CITY OF ALBUQUERQUE

May 25, 2022

**RE: Enterprise Rent-A-Car
5700 San Mateo NE
Grading & Drainage Plans
Engineer's Stamp Date: 05/04/22
Hydrology File: F18D052**

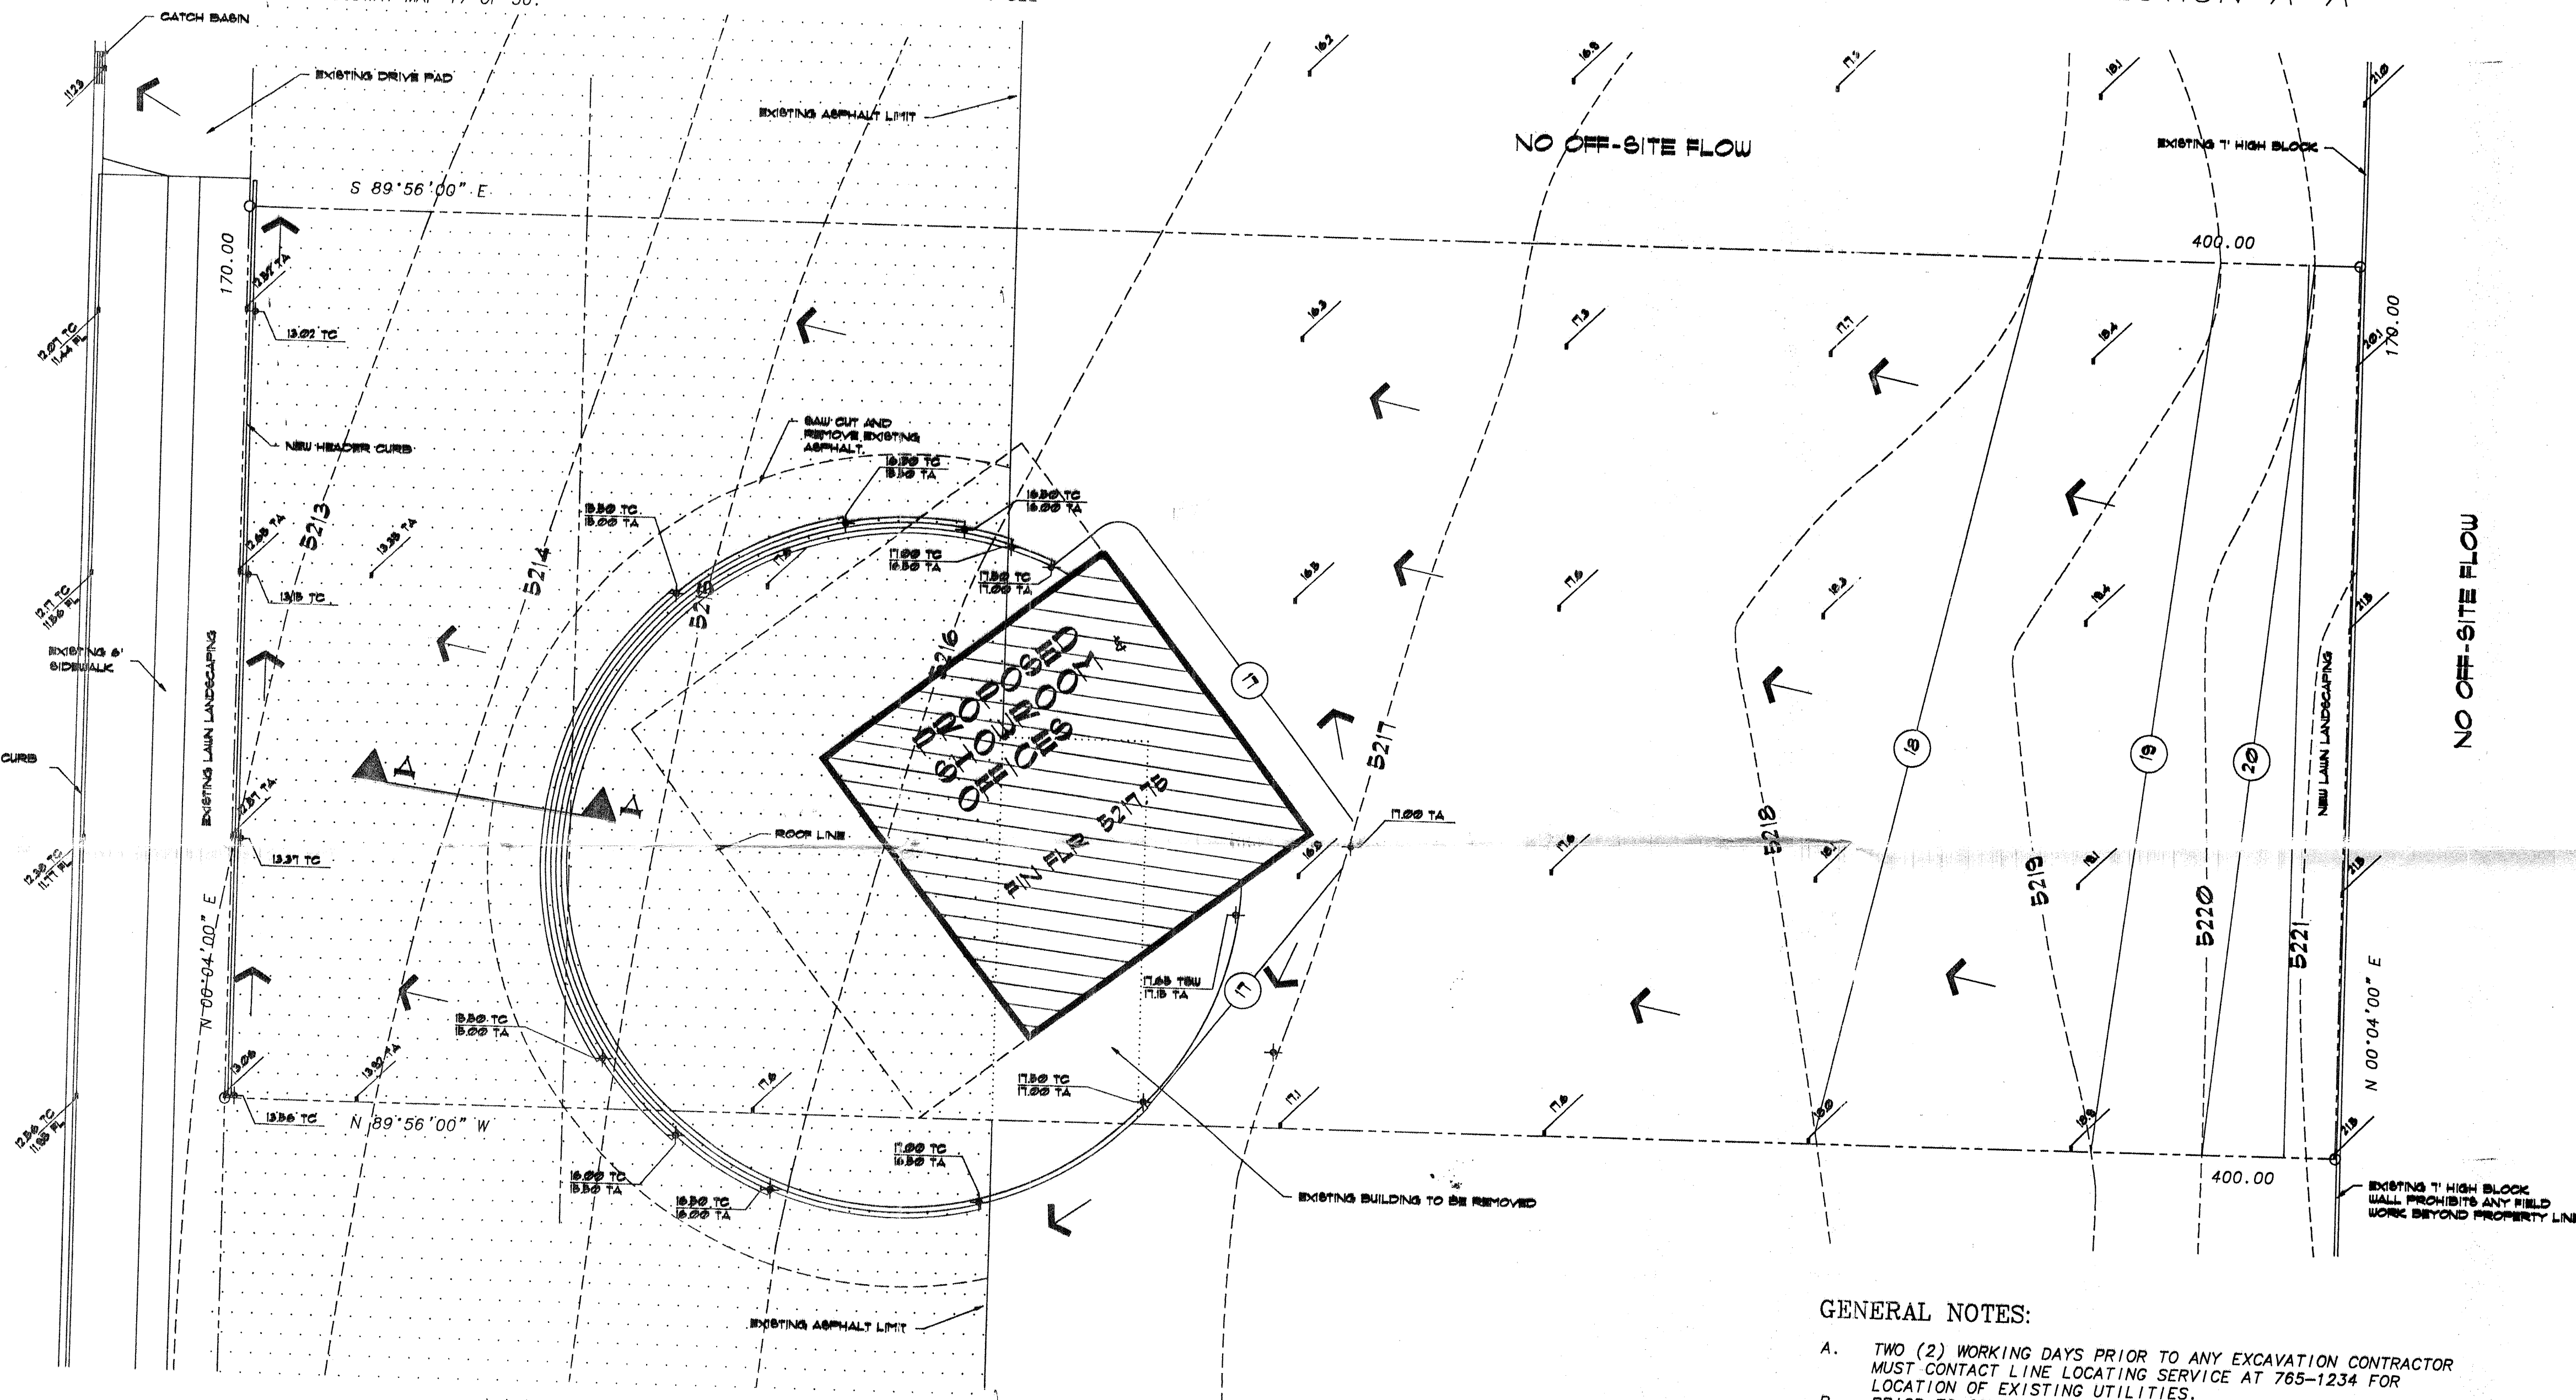
2. Please provide the Benchmark information (location, description and elevation) for the survey contour information provided.
3. Overlaying the latest aerial with the site plan and there are several discrepancies such as the existing landscape areas along the north of the property, and the relocation of the existing ADA spaces. Please verify that an actual topographic survey was done on this site.

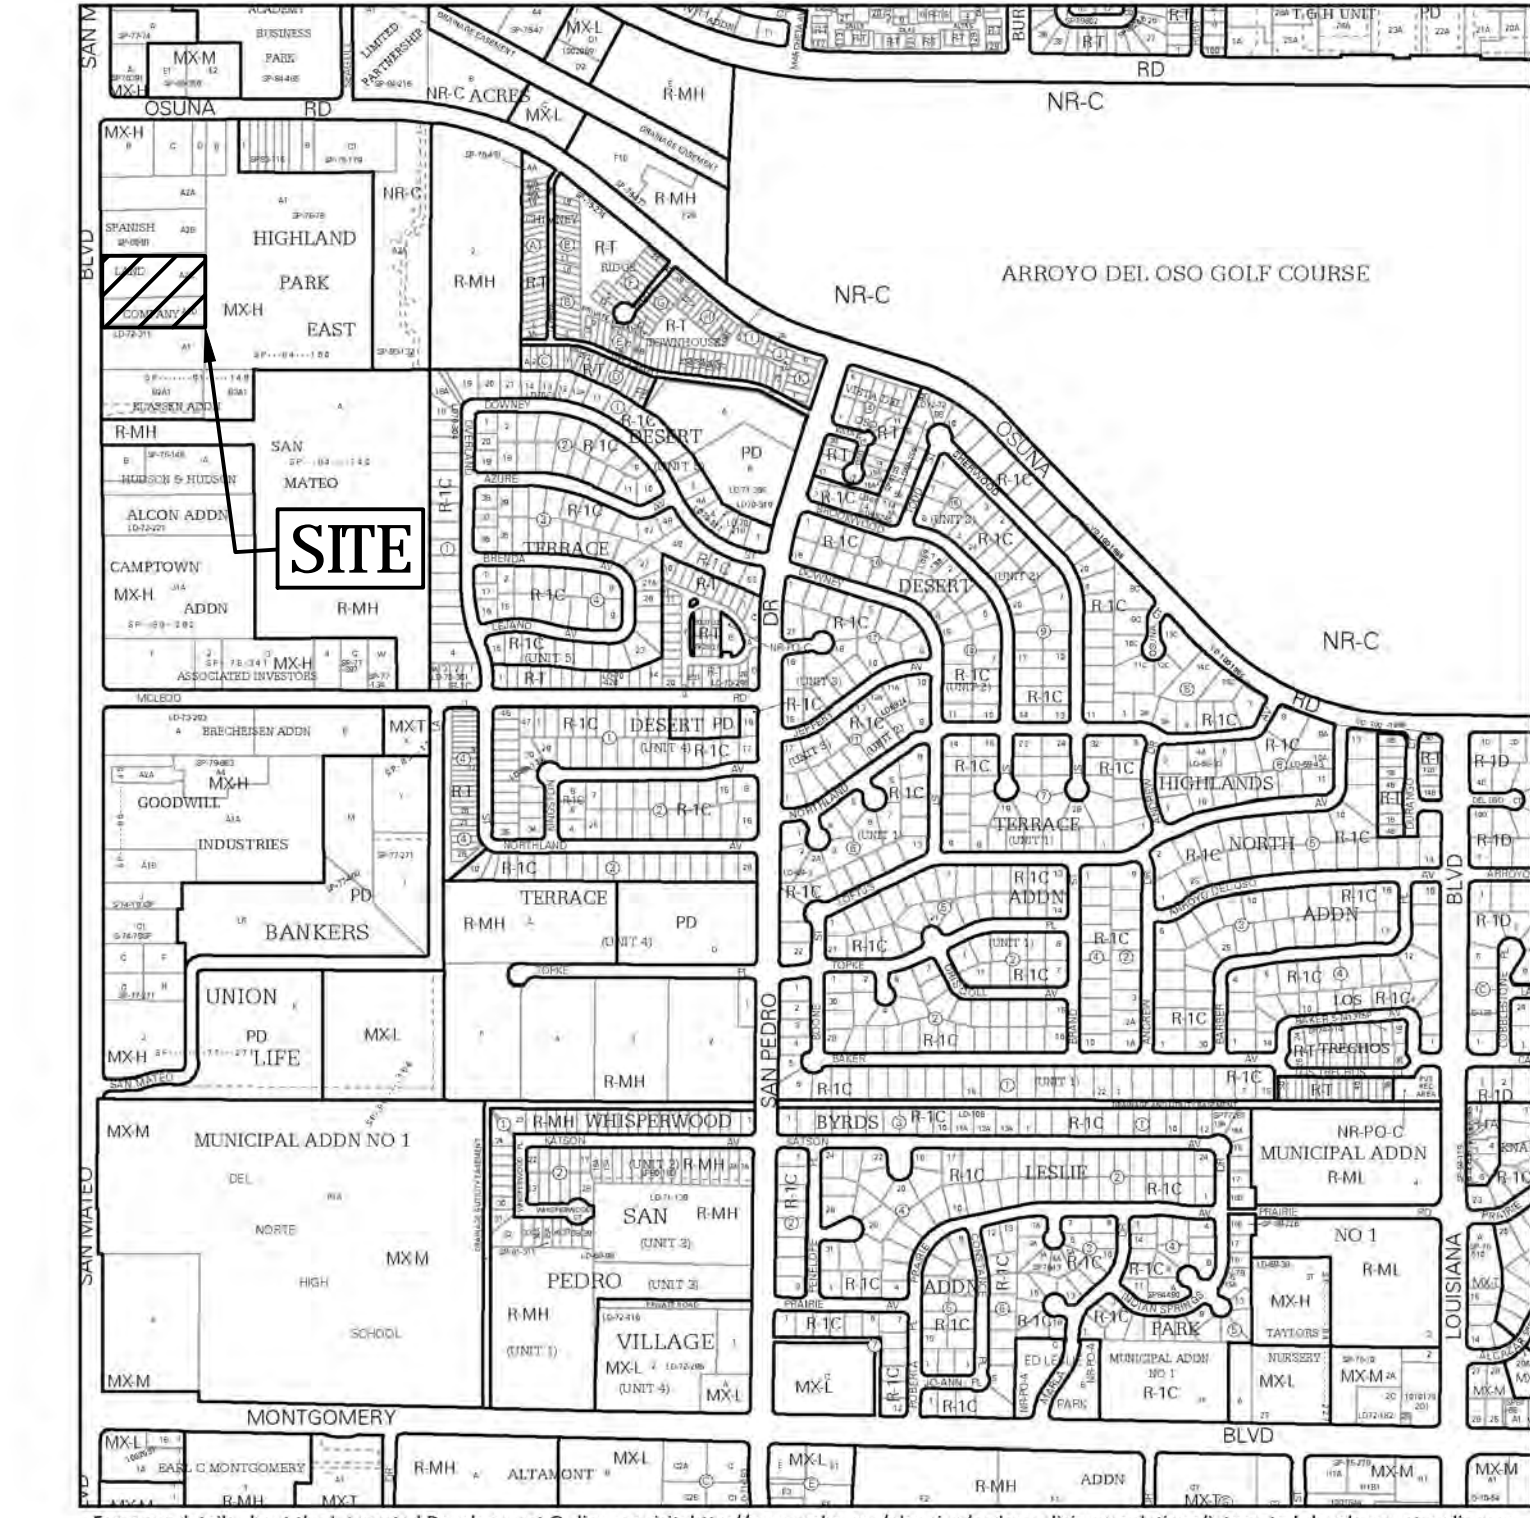
1. Stormwater Quality Ponds cannot be built within the City's R.O.W. Either relocate the ponds on-site or use the Waiver of Management Onsite form and request a Payment in Lieu for the required Stormwater Quality Volume.
